SSD 13_6123 Campus Improvement Program 2014-2020 for Camperdown-Darlington Campus

I write in response to the publicly advertised State Significant Development proposal for the Sydney University Campus Improvement Program 2014-2020 (SSD 13_6123) and provide the following National Trust comments on this proposal.

Graham Quint
Director - Advocacy

01 HEALTH - PROPOSED ENVELOPE PLAN

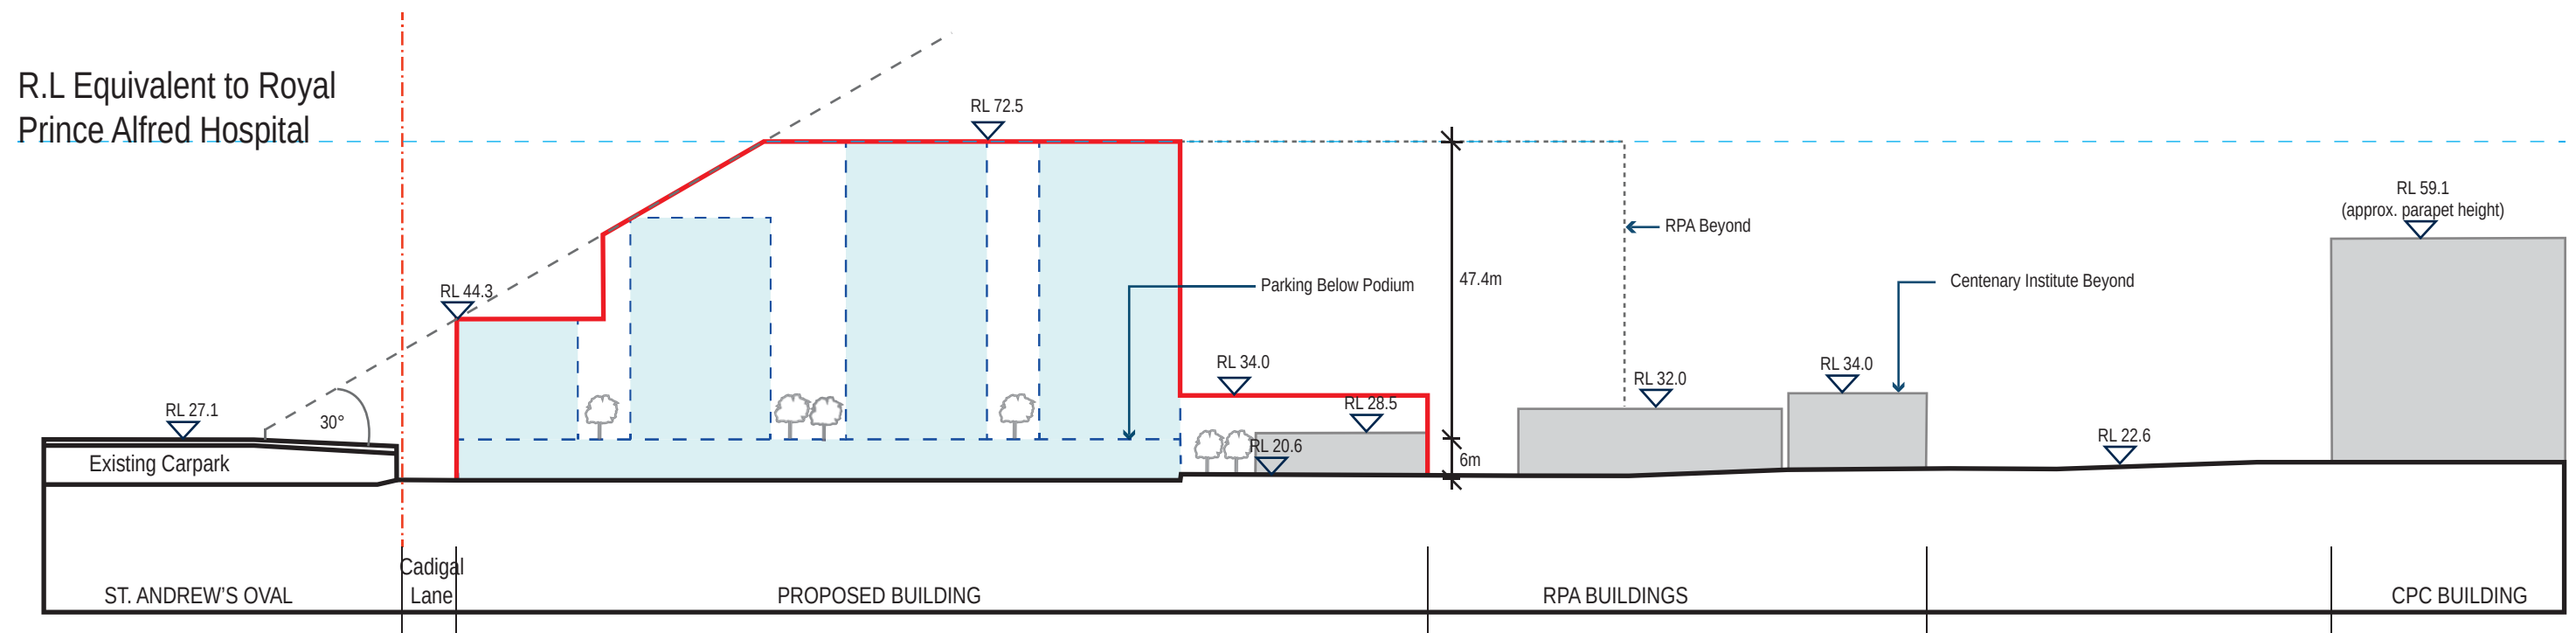
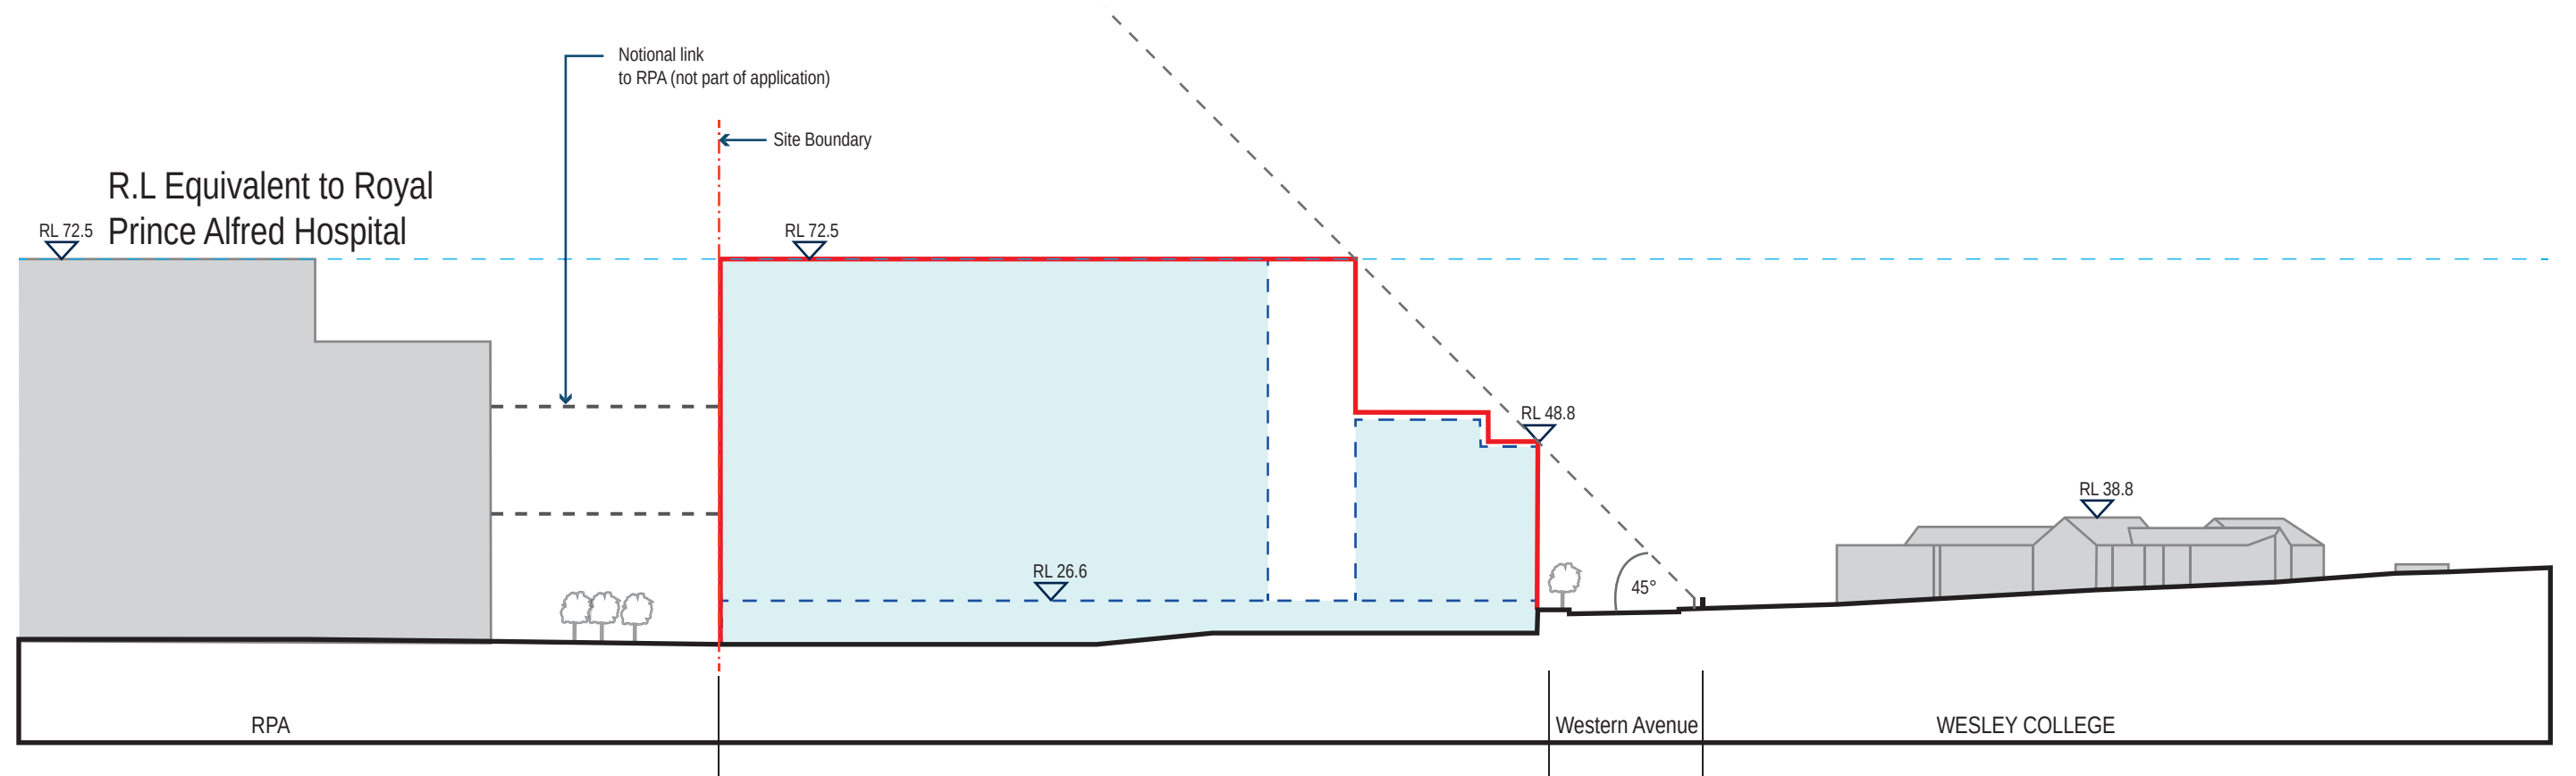
The Trust is also concerned that the proposals for Precinct D – Health are a conglomeration of massive new rectangular block constructions which will dwarf Wesley College and the adjacent St Andrews College buildings. The Conservation Management Plan identifies B3 – The “Wesley College / Blackburn Circuit Axis” as a feature of the University. This Axis will cease to exist. Wesley College will have no relationship to the Blackburn Building (A6), as the area between, including almost all of the current open space) will be consumed by huge new buildings covering this area.

The height of buildings proposed will dominate older significant buildings. Even the old Institute Building on City Road appears small when compared with what is proposed. This is in contrast to the present Merewether Building, which is low key and human in scale. Although building envelopes are proposed to be stepped, in some precincts the overall scale of what is proposed is overwhelming. Proposed setbacks are minimal and leave little opportunity to appreciate boundary walls which are evidence of past uses. This also presents a challenge to maintaining significant boundary fabric during the construction phase.
